Planning Application Ref: EP/113/19/T

Location: 24 Mill Pond Way, East Preston, BN16 1TG

Description of works: Crown Reduction by 3m and Crown Thin by 30% to 1no. sycamore tree. Crown Reduction by 2.5m and Crown Thin by 20% to 1no. Norway maple Crimson King tree

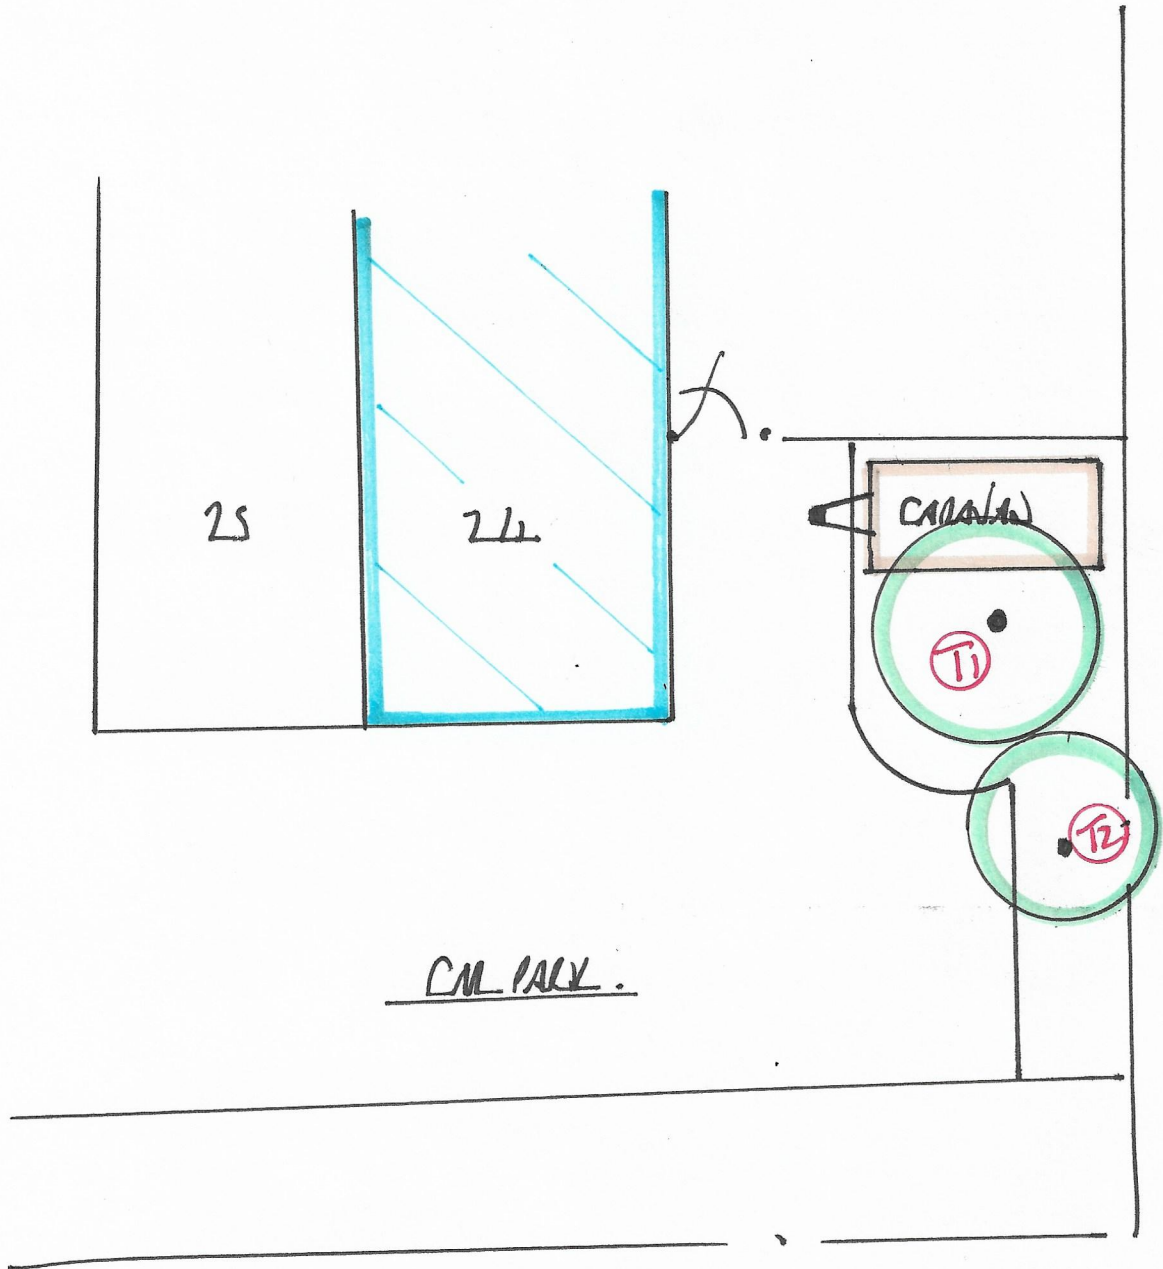
- Both trees appear generally stable and in fair physiological condition at this time. They have a history of past crown reduction work and have grown-on well.
- Both trees have sustained mechanical damage at low level. T1 displays numerous scars around its main stem having been deliberately hacked with a heavy bladed instrument in the past. T2 has sustained a large, irregular wound from its base to approximately 1m height.
- They grow at the side of the property and by virtue of their height can be seen from surrounding properties, commercial premises and public highway – as such they have some public amenity value.

- On this occasion, I cannot say the proposal to reduce its overall height and spread with a view to restricting its growth is justified and consistent with previous works approved by the Local Planning Authority as I have not been able to retrieve a past permission for such an operation.
- The work proposed is necessary to mitigate a developing risk of structural failure in both trees and with adequate regrowth since the last operation to reduce their crowns – is therefore justified on arboricultural grounds.
- While a temporary loss of aesthetic value is inevitable, satisfactory canopy renewal and recovery should occur if the work is undertaken to a high standard and at an appropriate time of year.

- I recommend **CONSENT** for this application, subject to the following conditions:

- Where whole branches are to be removed and final cuts made close to the trunk or branch union they are to be made as shown in Figure 2 of BS3998:2010
- Where branches are to be shortened back the final cuts are to be made at the correct angle shown in BS3998:2010 and adjacent to a live bud or lateral.
- The removal of crown material which has developed since the last operation must be done sympathetically and with respect to established 'knuckles' so as not to extend beyond the point of origin.
- The long-term vitality of these trees is best respected when significant pruning work such as proposed, is undertaken during either the summer (June to August) or mid-winter (late-December to early-February) periods. The work must only be undertaken during these periods.
